Application for Planning Permission for Works or Extension to a Dwelling

Development: Side extension to bungalow and internal alterations.
Re roofing with standing seam metal roof and additional insulation.
Location: Sundance Yapton Road Barnham PO22 0BQ

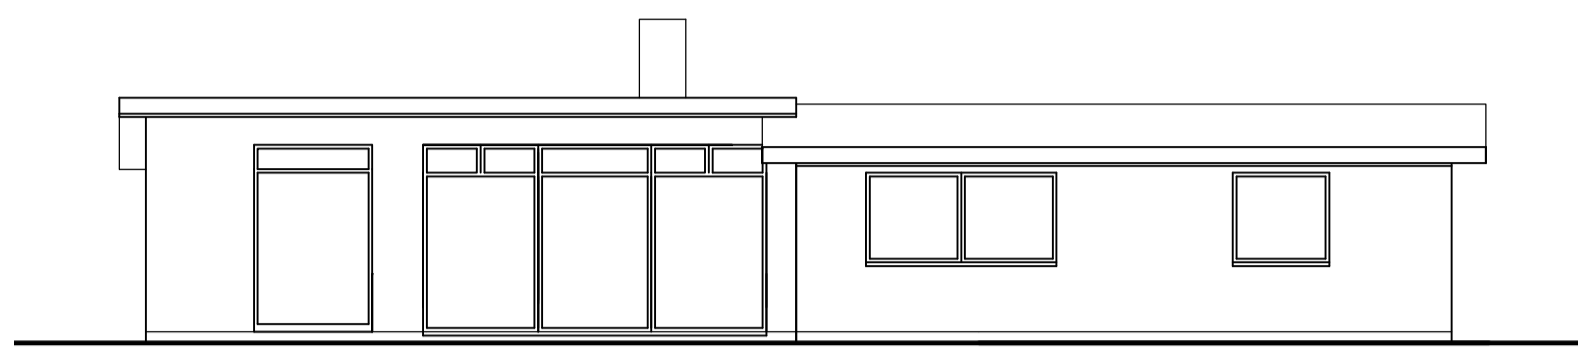
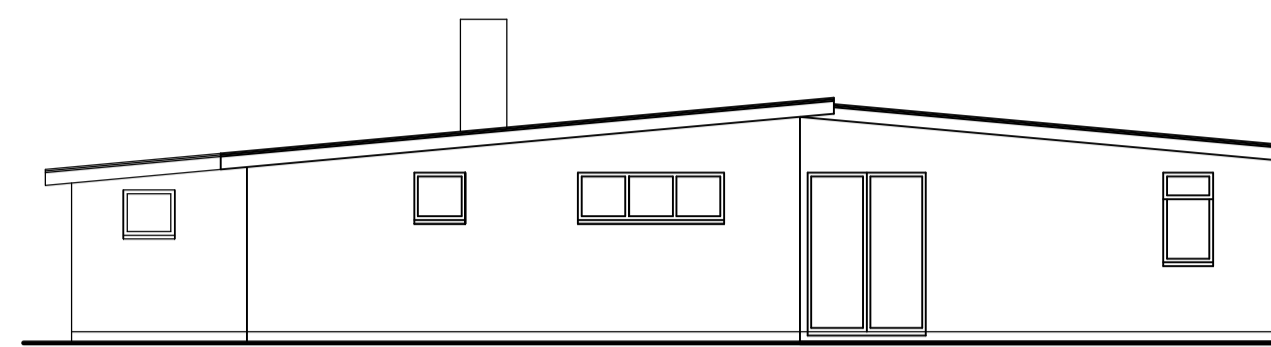
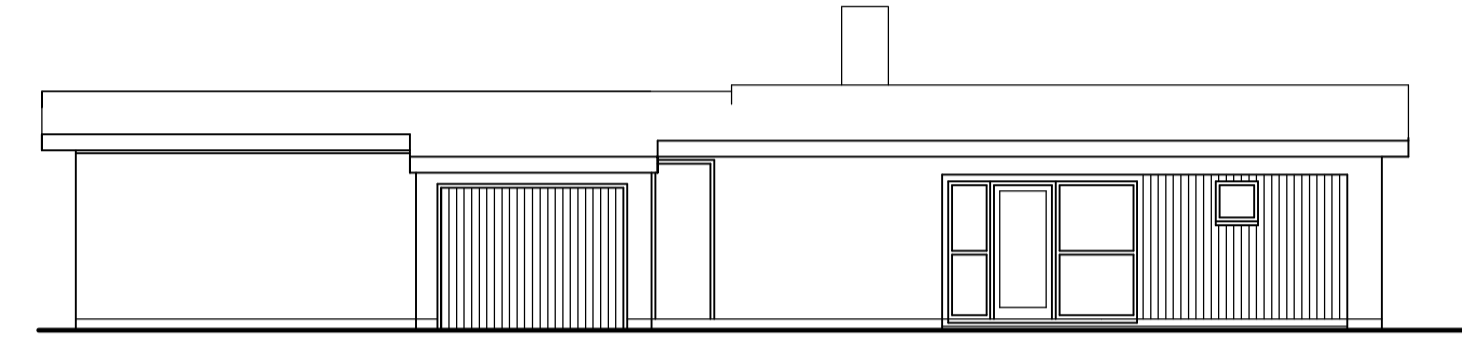
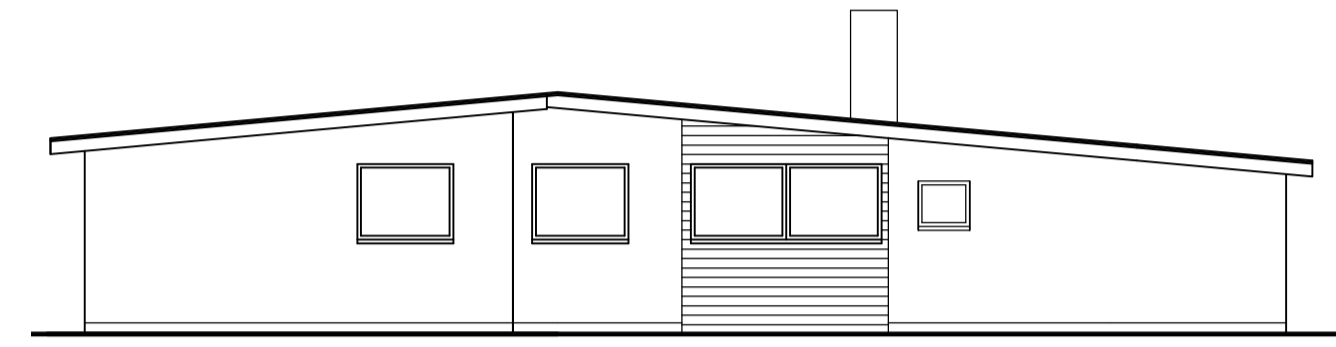
Existing Elevations

The existing front elevation has been labelled as rear, please review and amend.

SITE PLAN  
SCALE 1:500

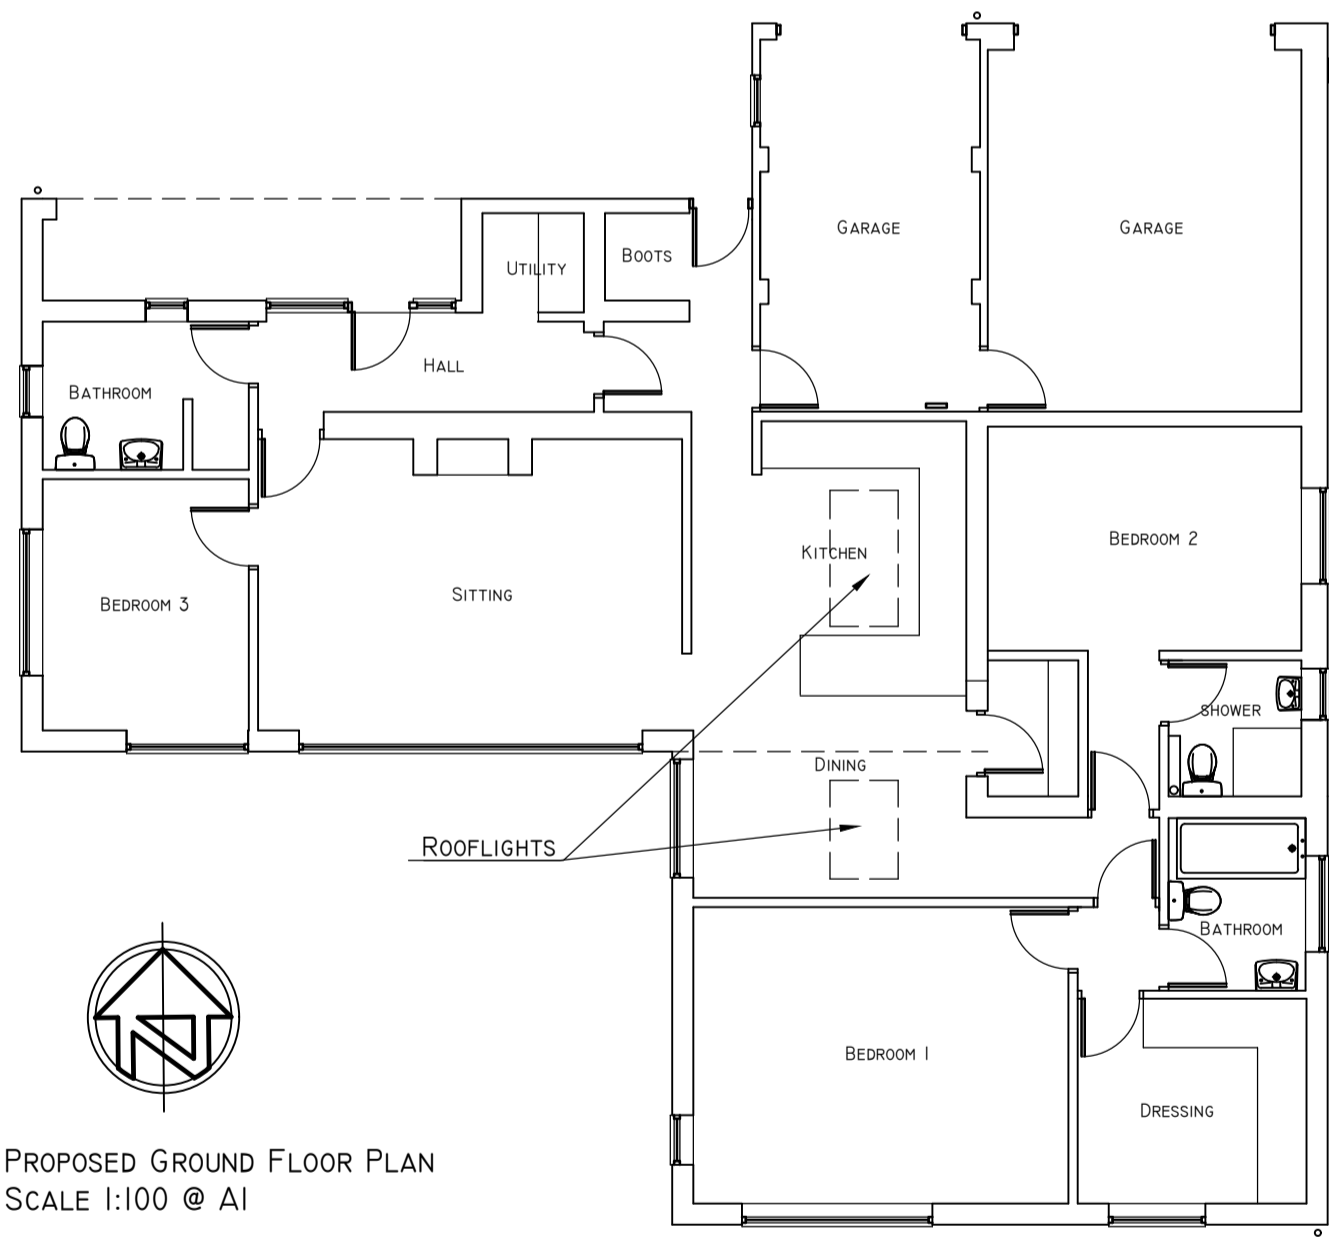
Block Plan

You are required to have dimensions from the proposed extension(s) to all site boundaries. Please amend.
